From: Andrew Beattie
Sent: Thursday, 20 April 2017 3:16 PM
To: Taylor Richardson
Cc: Kelly McNicol
Subject: Smeaton Grange RRF - Request for Information
Attachments: form_political_donations_disclosure_minister_or_dg.pdf

drawing title  
GROUND FLOOR PLAN

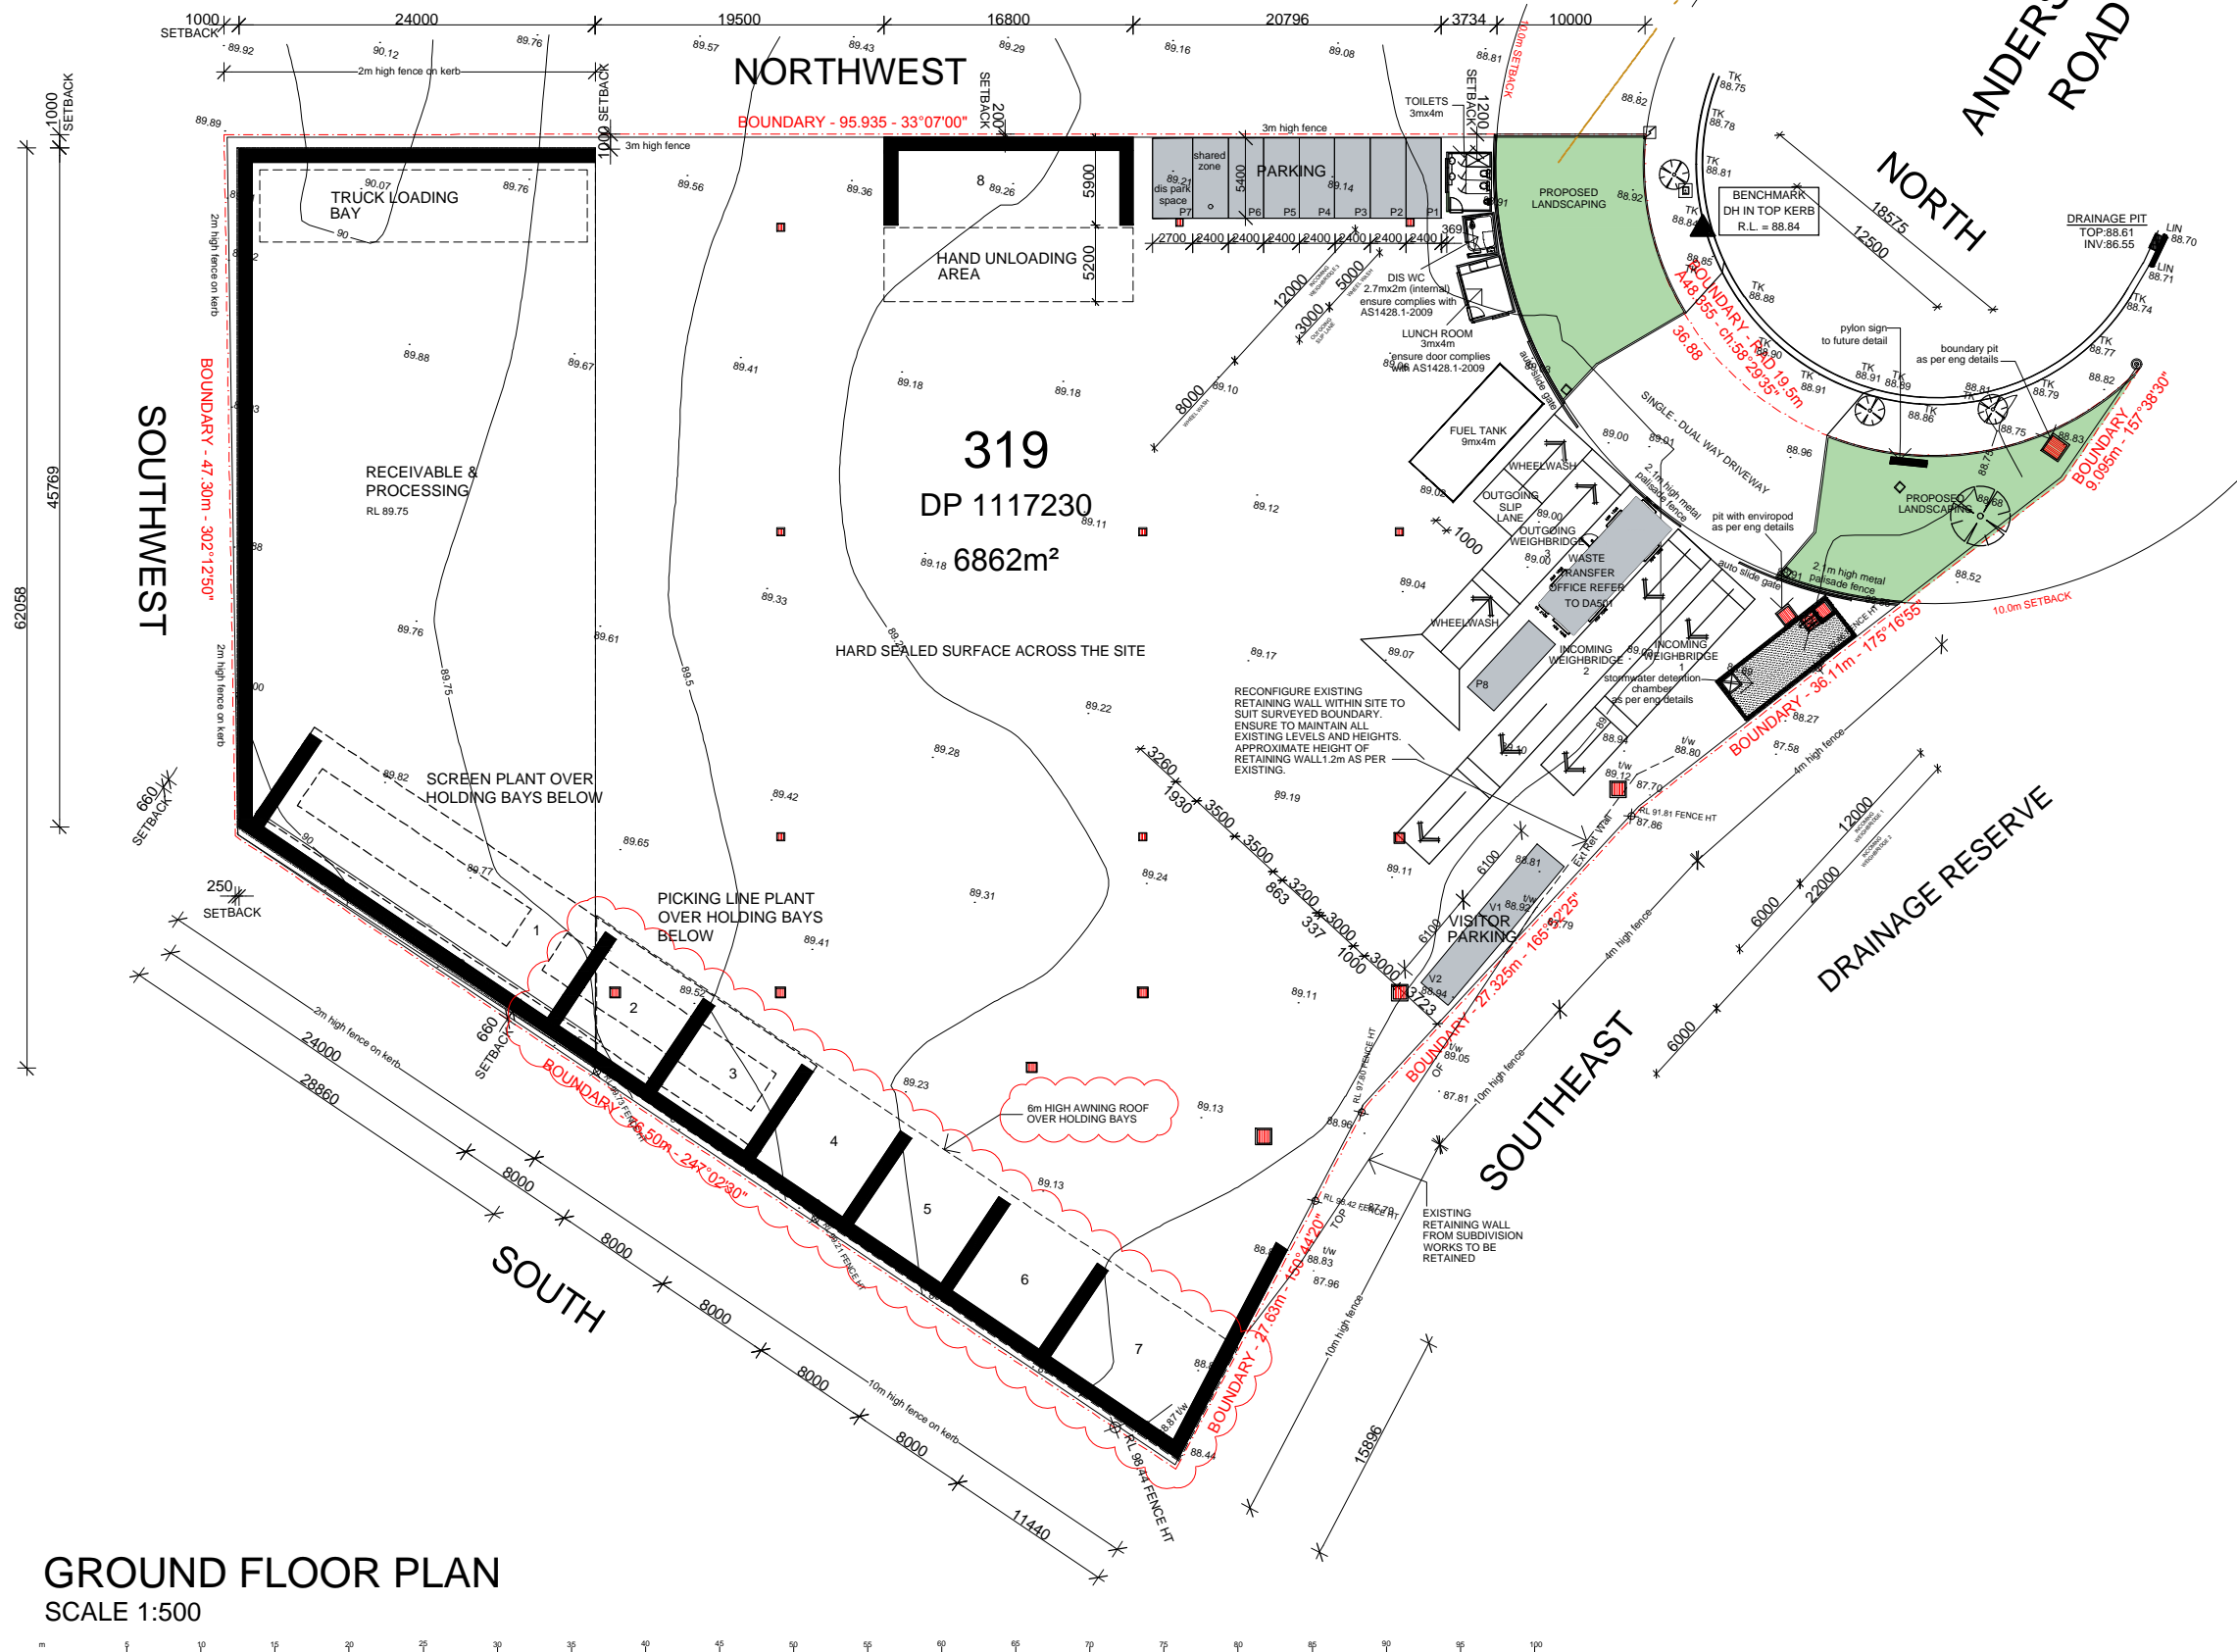
It is noted that Bay 1 (fines) and Bay 6 (timber) would be covered. The Department supports this approach, however believes that based on best practice, all external material storage bays should be covered for the following reasons:

- The EIS states that concrete, asphalt, tiles and bricks would be accepted at the facility. These materials are known to leach contaminants into the surface water over time, especially when exposed to rainfall events. Covering these bays would reduce the potential for any leachates entering the on-site stormwater management system; and
- To enable dust suppression and fire safety sprinkler systems to be installed.

It would be appreciated if you could provide a response to these matters (which may include a revised plan) to enable the Department to finalise its assessment of the external storage bays.
